Case Officer: Bob Neville

Recommendation: Refusal

Applicant: Mr R Bratt

Proposal: Erection of garage adjacent to approved dwelling and change of use of agricultural land to residential use

Proposed Ground Floor Plan

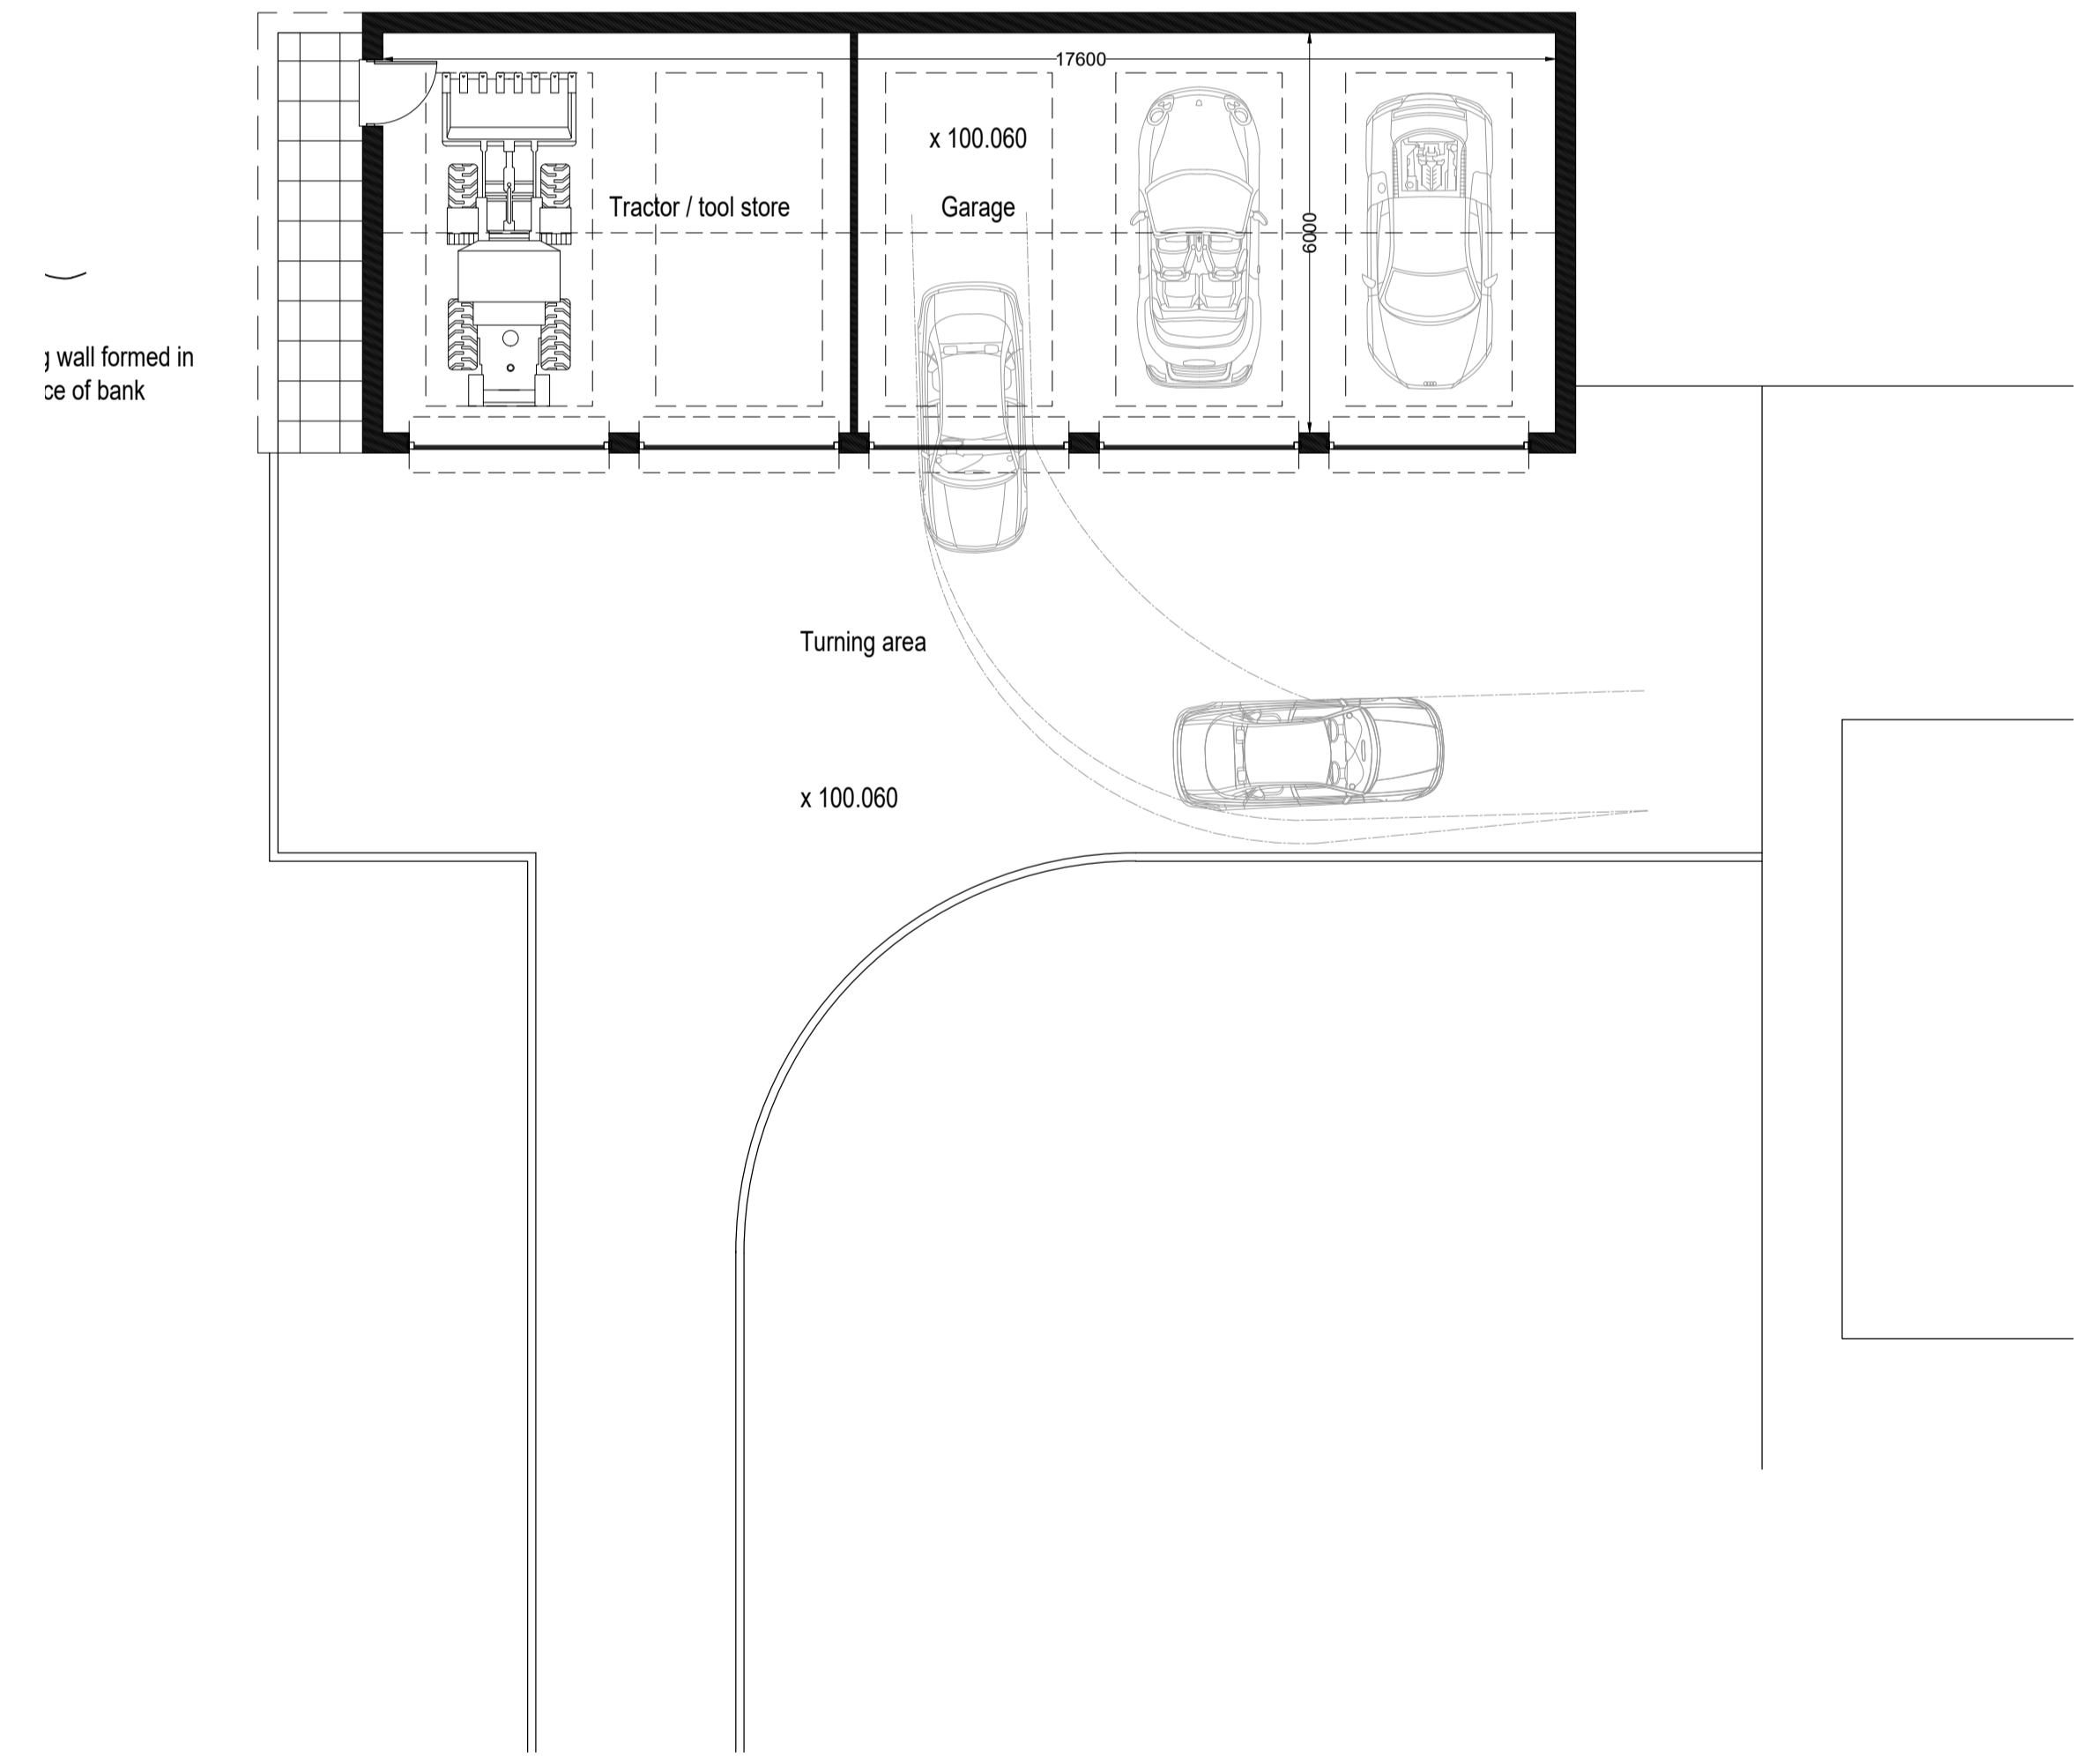
8.5. The proposed building (a 5-bay garage) would be a substantial building, of a scale above that usually expected for a 5-bedroom residential property; with a footprint of 127 sq m that would be almost a third of the size of the footprint of the main dwelling (in itself a substantial building), with a further 127 sq m of hardstanding to the front of the garage building for parking and manoeuvring. The applicant contends that the ancillary building would provide domestic garaging for the applicant's day to day vehicles; and given the relatively remote location consider secure garage/parking as

- 8.6. As noted above the proposed garage building is *substantially* larger than what might be considered a typical domestic garage. The proposed building would be sited to the north-west of the on-going development at the site and would be poorly related to and appear somewhat divorced from the main dwelling. Whilst materials are proposed to match those proposed on the main dwelling, the overall appearance of the building would appear somewhat more commercial than a residential garage, largely due to the number of bays proposed.

- 8.9. Officers have previously advised the applicant that the proposed building and extent of the proposed hardstanding are poorly related to the main dwelling, and its impact and relationship has not improved in the current submission, and further exacerbates the harm that would be caused by what is a substantial increase in not only the built form at this location but also the area of residential use at the site.

1. By virtue of its siting, scale and design of the proposed garage building, and the location and extent of the associated hardstanding, and the location and extent of the proposed change of use, the proposed development would result in an inappropriate form of development that would be unsympathetic to and relate poorly to the rural context of the site and would cause undue and unjustified visual intrusion into the valued rural landscape and open countryside. The proposals are therefore contrary to the provisions and aims of saved Policy C28 of the CLP 1996, Policies ESD 13 and ESD 15 of the CLP 2031 and Government guidance within the National Planning Policy Framework e.g. in respect of conserving and enhancing the natural environment.
